**Written Representation of Peter Goodyear
on behalf of Fordham (Cambs) Walking Group**

Sunnica Energy Farm
Planning Inspectorate Reference EN010106

November 2022

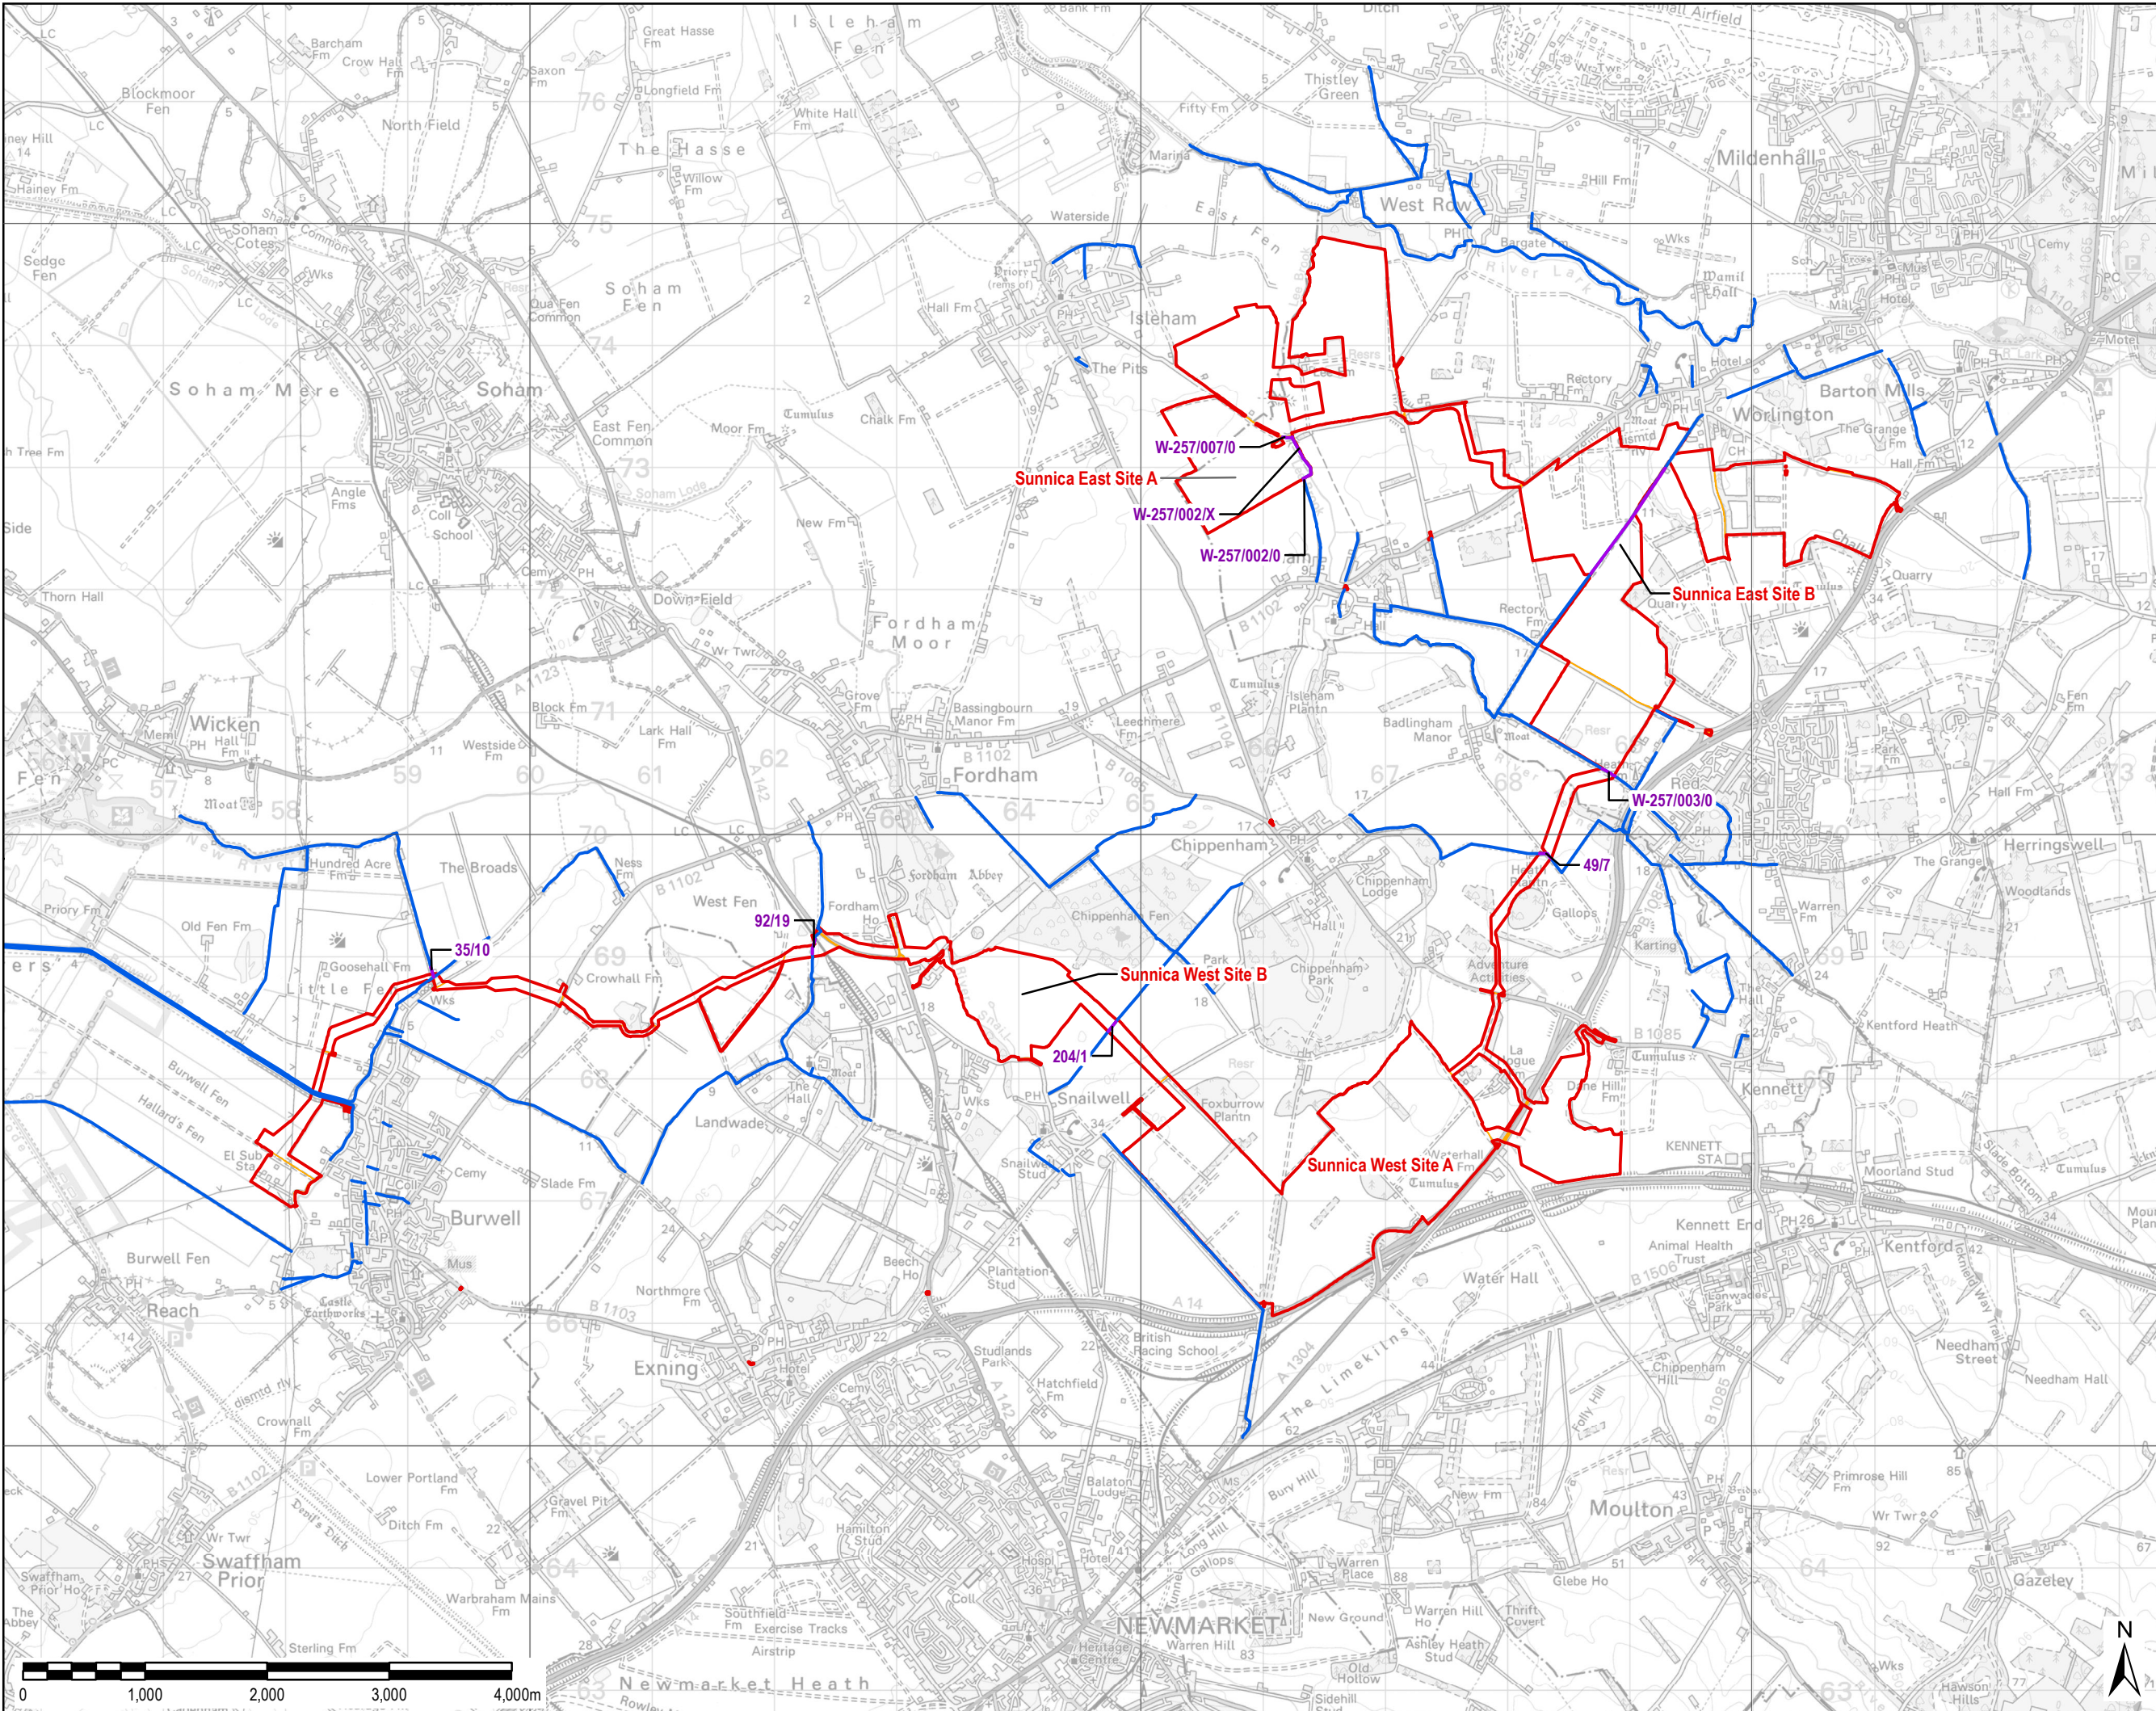
3.8 Schedule 8 of the DCO Works, land over which the applicant seeks rights rather than ownership does not provide for public permissive access routes. This is felt to be a fundamental flaw in the draft DCO.

3.12 FCWG were under the impression that there were four not three 'potential' permissive routes proposed by Sunnica: One parallel with Beck Road Isleham; one west of Green Lane Worlington; one west of Golf Links Road Worlington and one south of Elms Road. These are shown on the applicant's Figure 11: Post Construction PROWs, including the Permissive Paths at paragraph 4.6.2 of the Environmental Statement, Appendix 13B: Transport Assessment.
